Traffic Impact Study

Esteban Rodriguez Site

El Paso County, Colorado

PCD File No. SP245

Figure 3 - Site Generated Traffic Volumes and Distribution

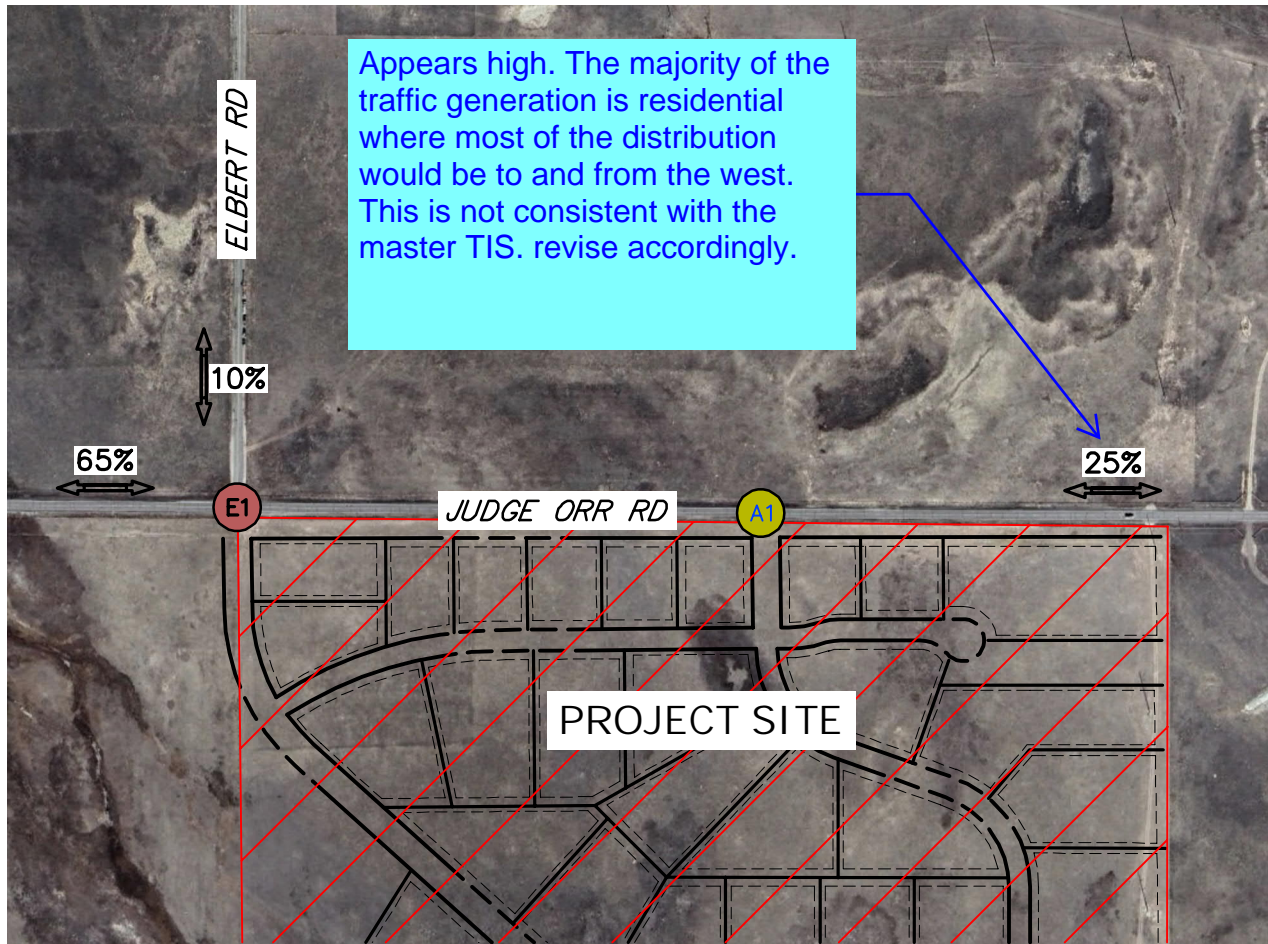
Unresolved review comment 1:

identify the ADT on all figures per ECM B.8

Review comment 2: Unresolved. Please address.

Review comment 1: Identify which of these is AM and PM peak hour traffic. Provide a legend, typical on all figures
 Review comment 2: Unresolved. Please address.

Figure 5 - 2029 Opening Day Background Traffic Volumes

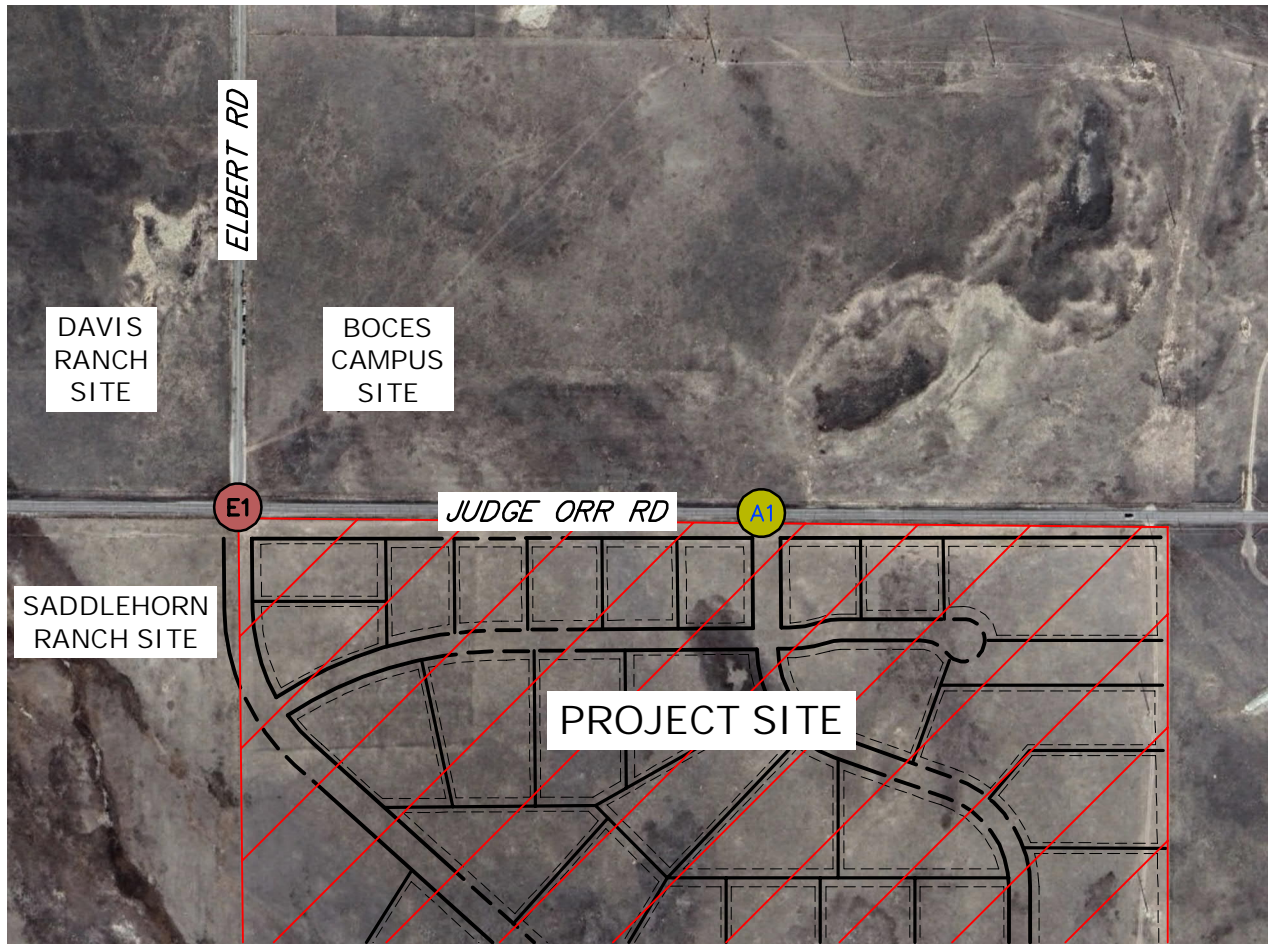
Review 1 Comment: This is not consistent with the master TIS. The master TIS identified a 3% initial growth rate (first 6 years). Revise accordingly.
Review 2 comment: Unresolved. Please address.
